From: Mark Eaden <[REDACTED]>
Sent: 17 February 2026 12:46
To: planning@arun.gov.uk; Iqraa Malik
Cc: Cerys
Subject: Planning application EP/11/26/HH - validation requirements for Location Plan.
Attachments: Householder-Validation-Requirements-List-2024.pdf

1 Site Location Plan
1:1250

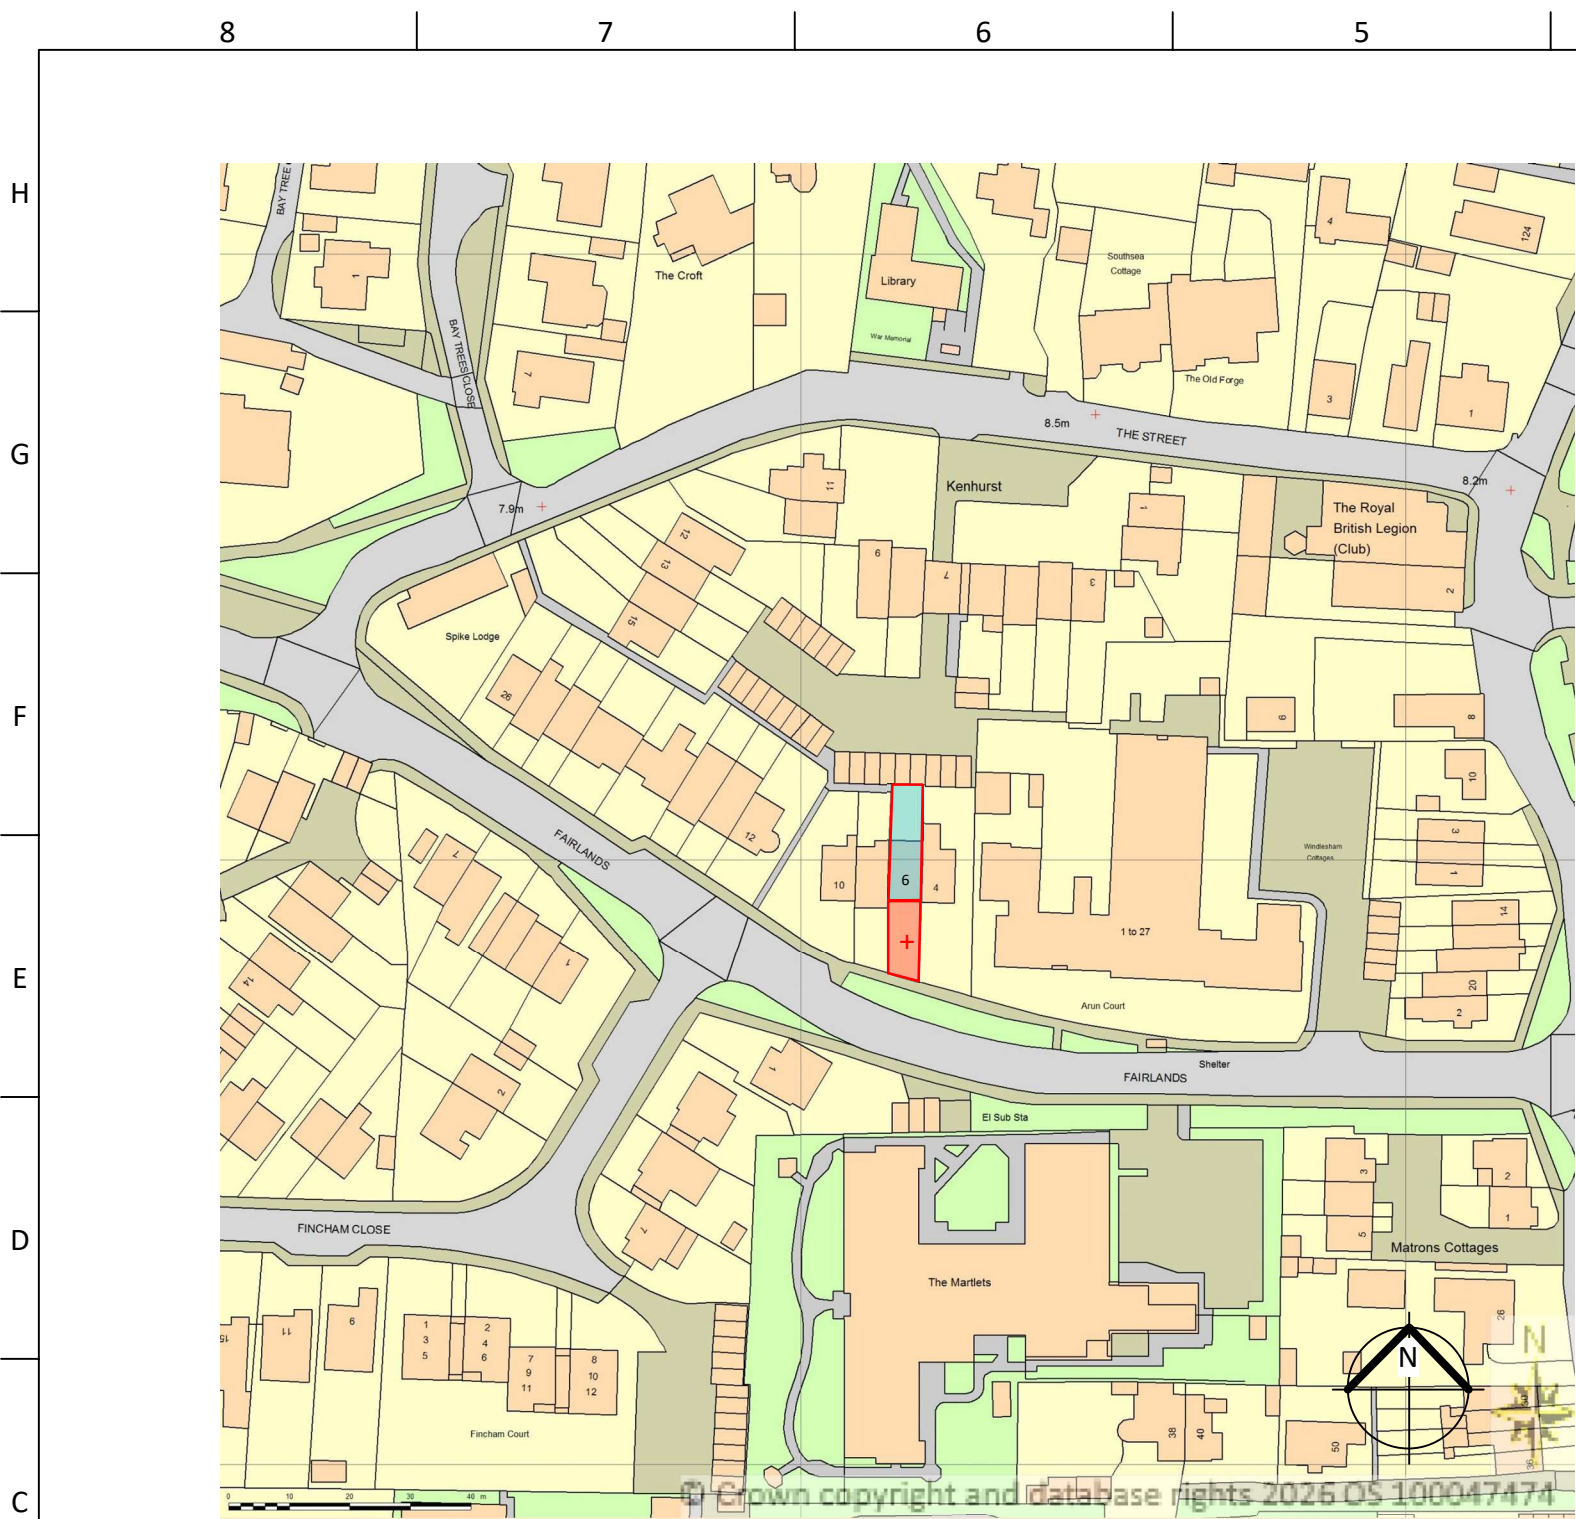
Unfortunately, this application is still invalid as the location plan requires a solid red outline around the site boundary, the current outline is only around the proposed site area. Please review and amend.

This is exactly what is shown on the location plan provided with the application, extract below. The application is for fences to the front of the property only. No further work is to be done on my property. Please therefore clarify what further changes you require. I am happy to take a call on the number below.
